CITY OF PORTLAND

BUILDING PERMIT

Job ID: 2011-05-1189-ALTR

has permission to Change-of-Use, Single Family Residence with Accessory Dwelling Unit provided that the person or persons, firm or corporation accepting this permit shall comply with all of the provisions of the Statues of Maine and of the Ordinances of the City of Portland regulating the construction, maintenance and use of the buildings and structures, and of the application on file in the department.

1st Level Floor Plan and  
 Accessory Unit Floor Plan

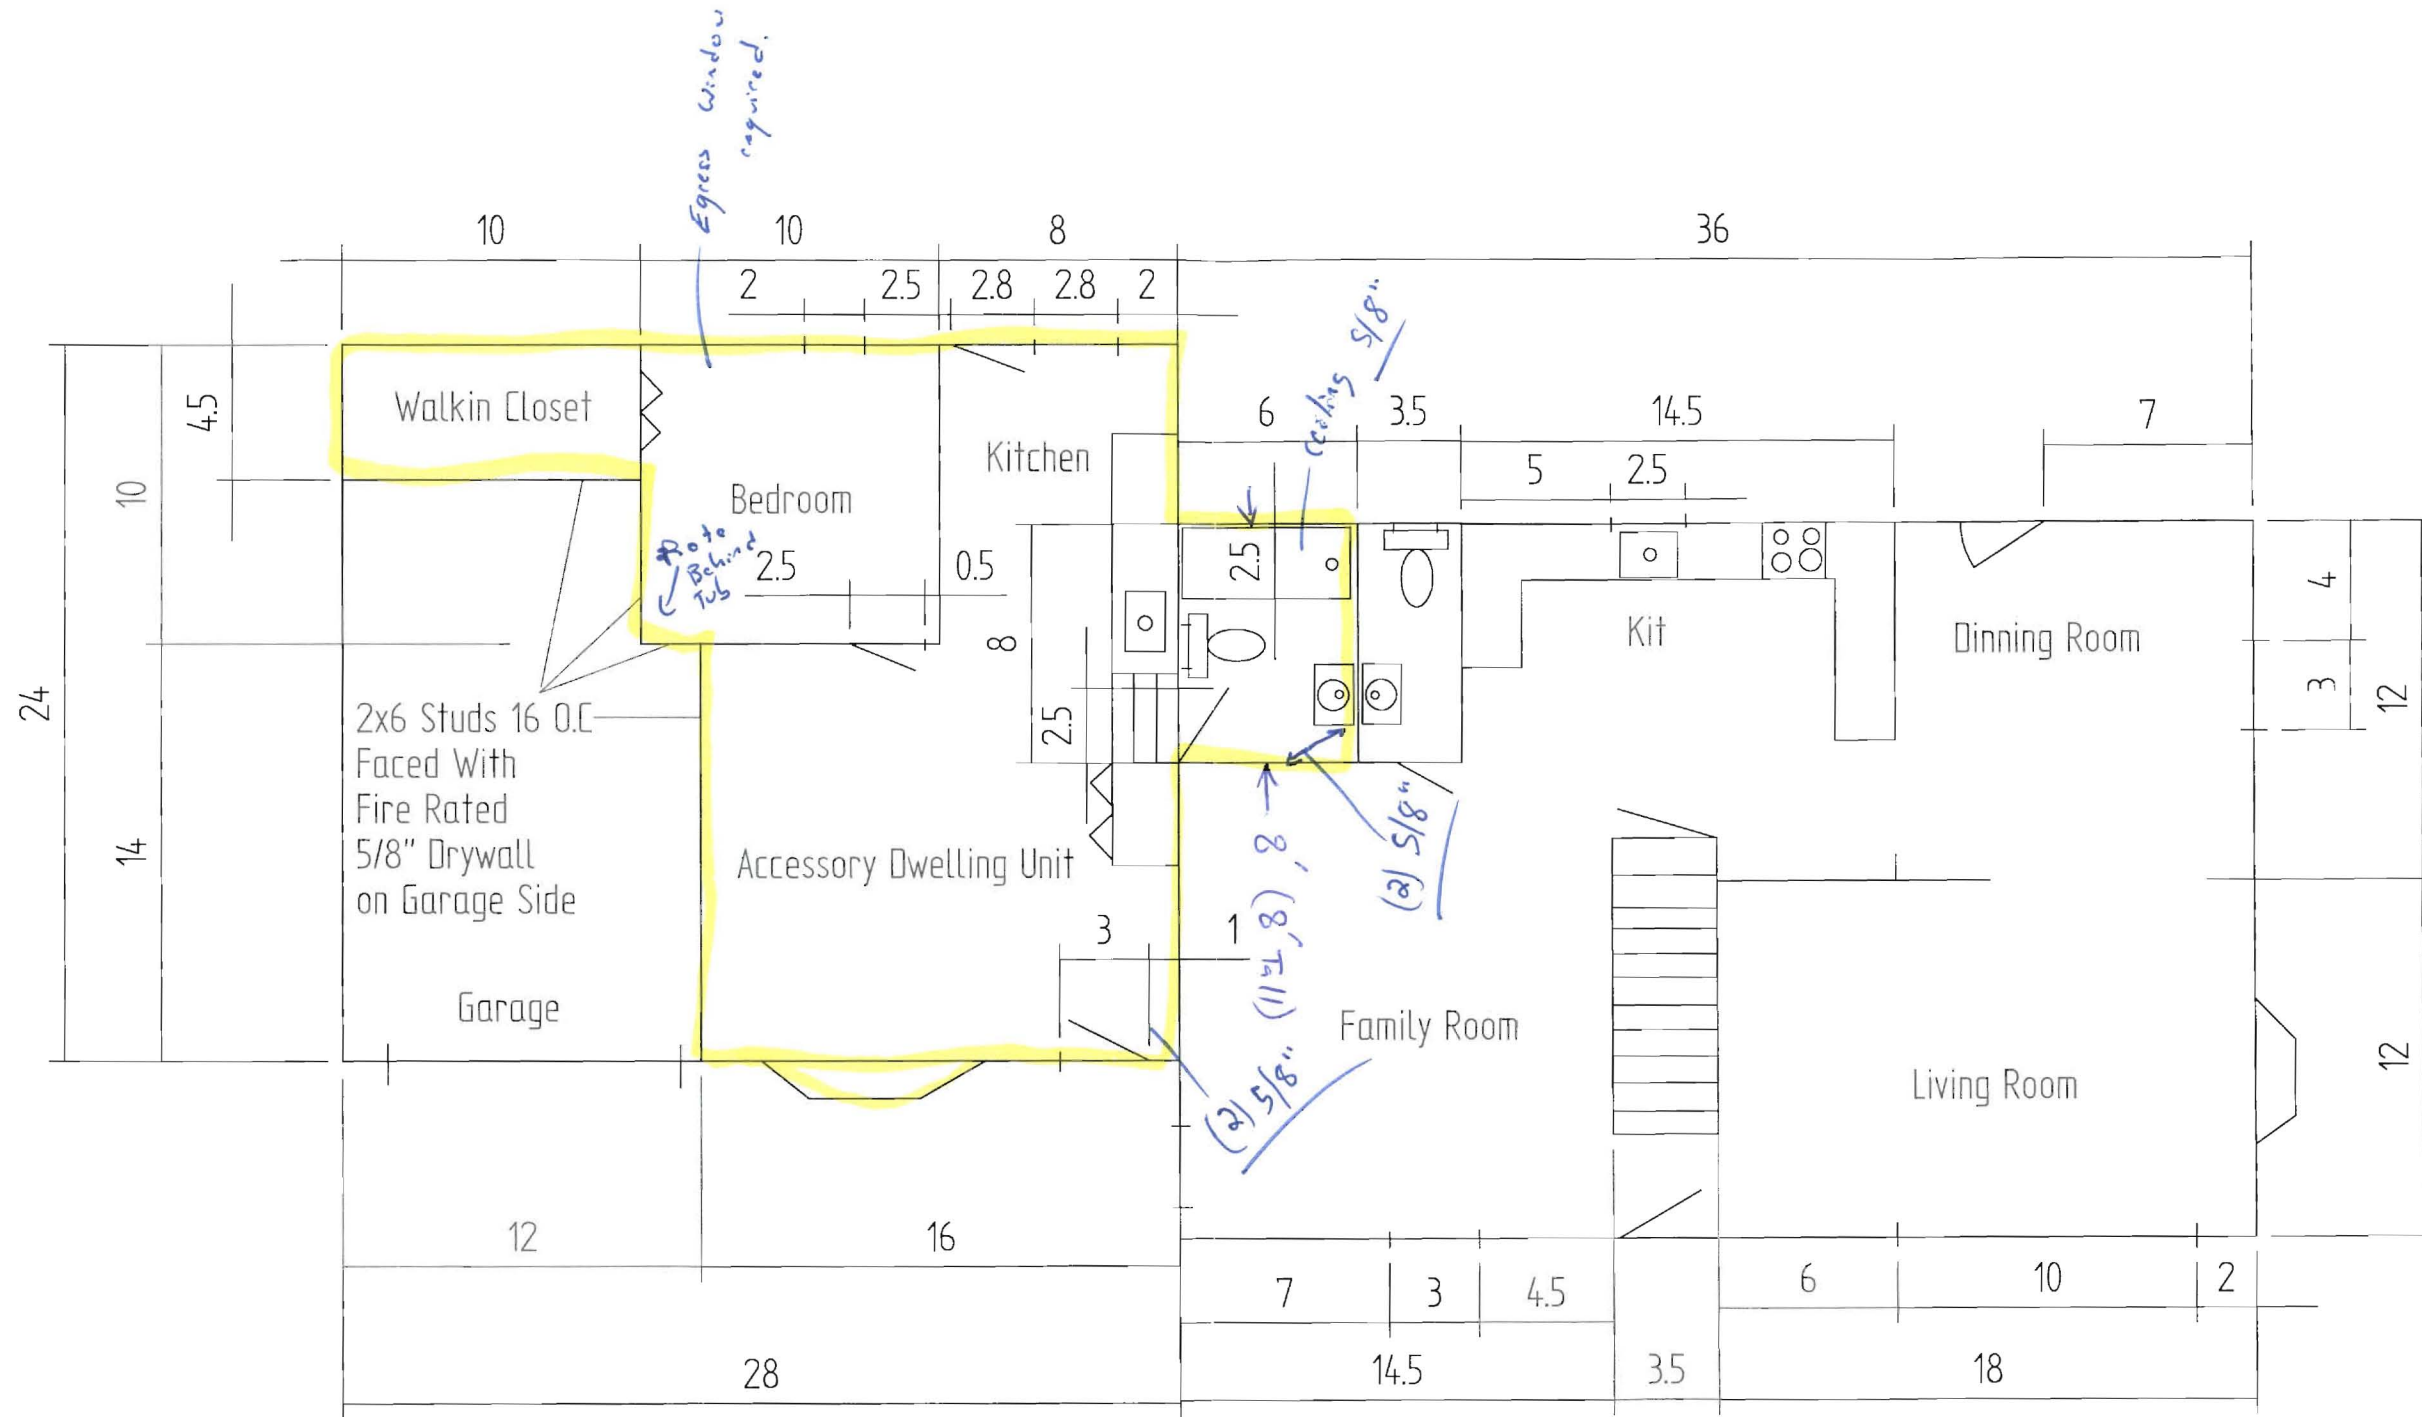
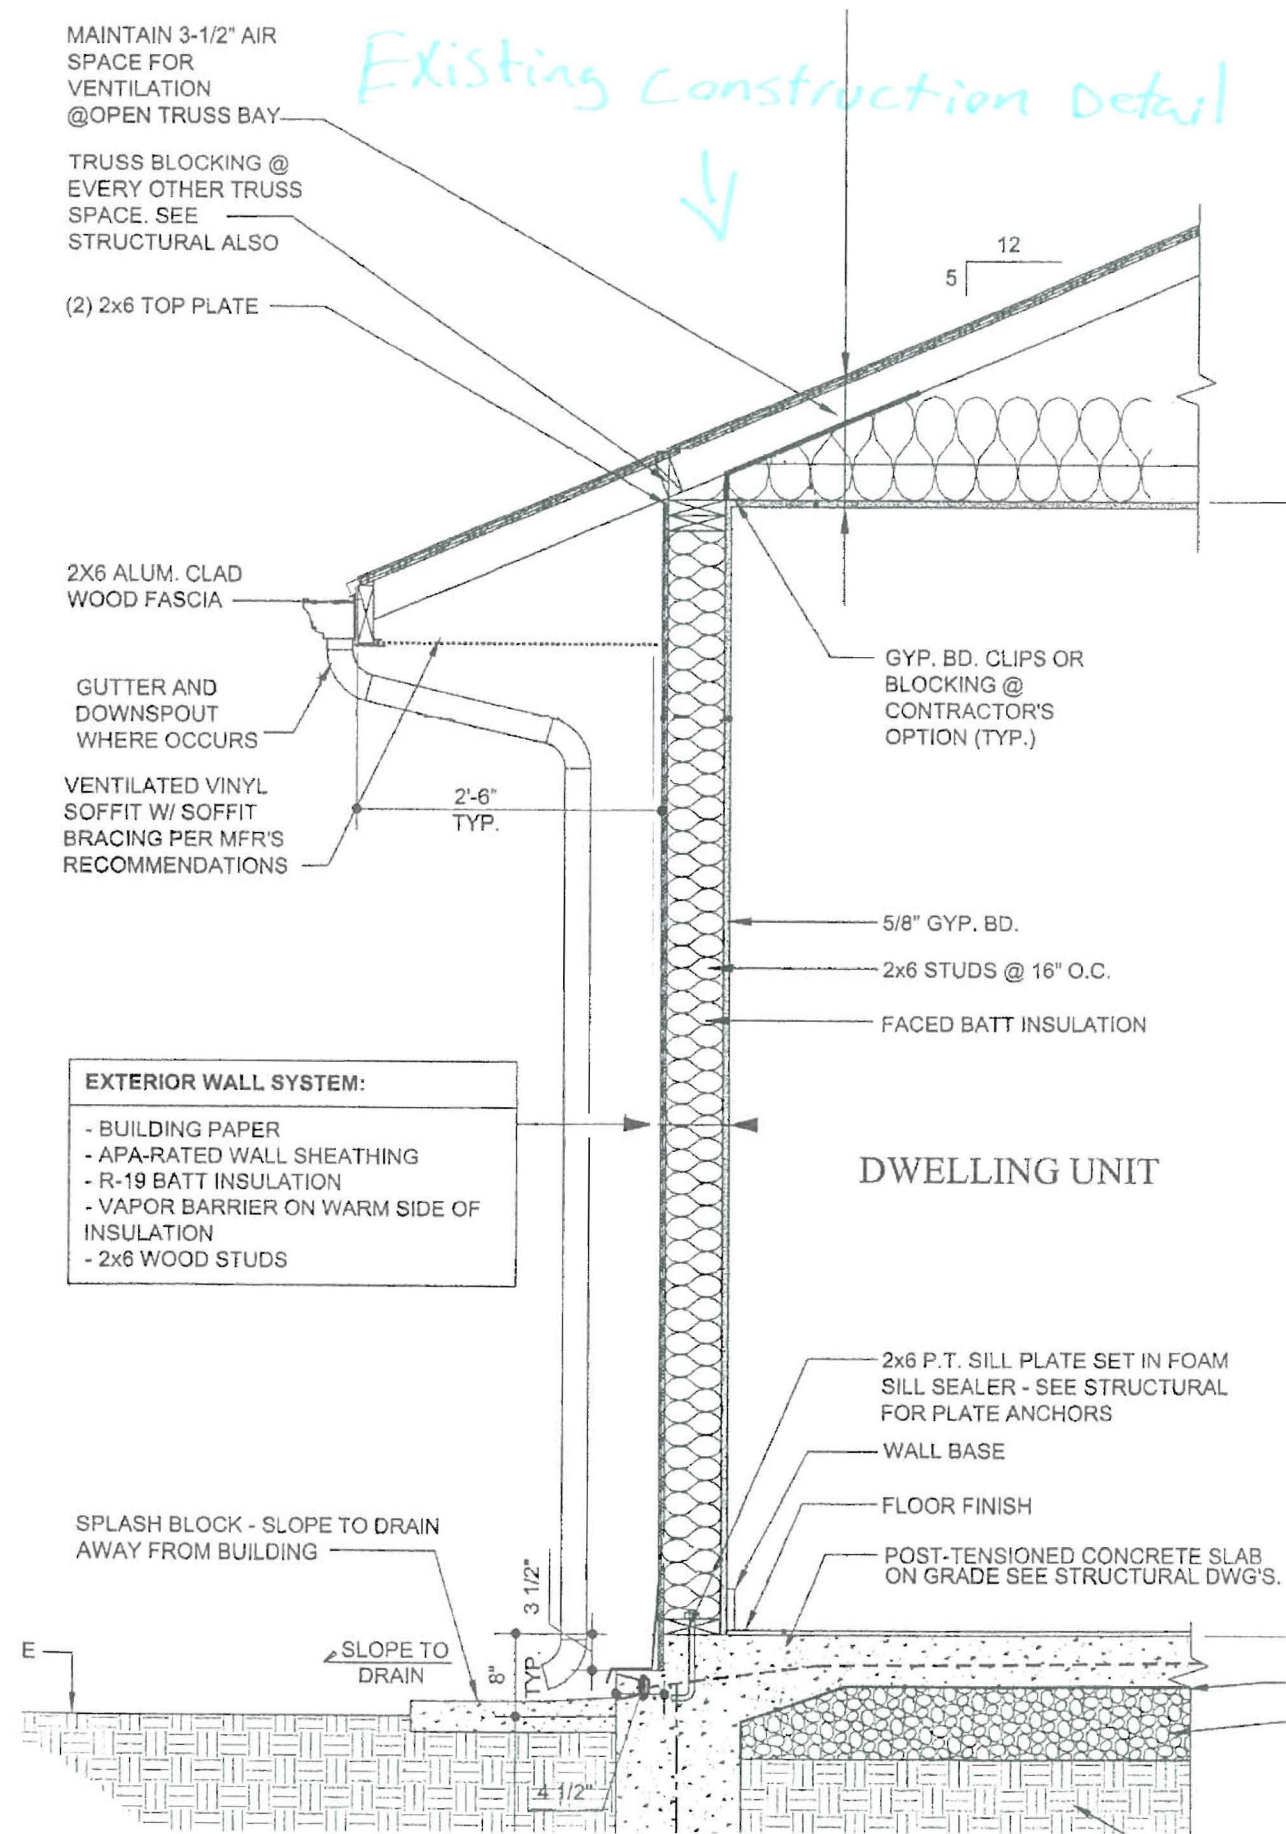
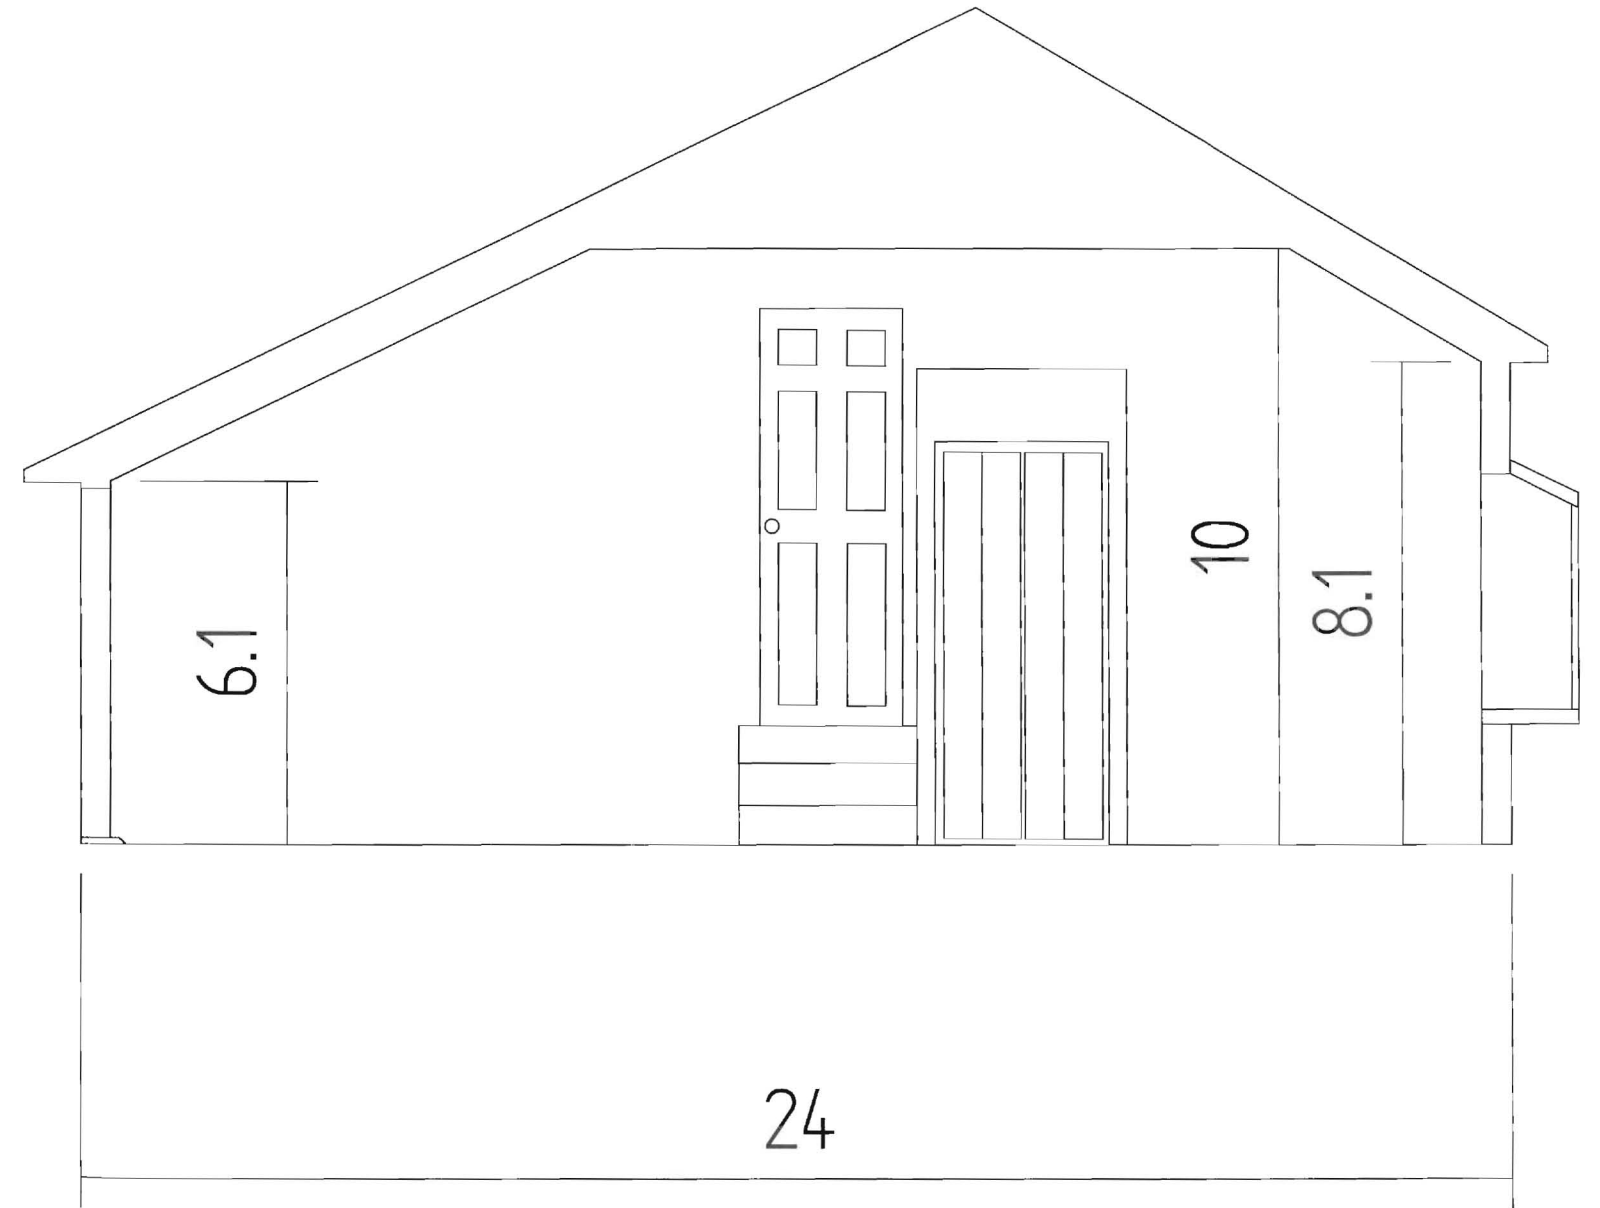
- 06/09/11
- * Interior wall separation units (2) 5/8" Gypsum
 - Garage to unit - 5/8" Gypsum
 - Egress window required/or Escape
 - SA/CO Det. required JCA
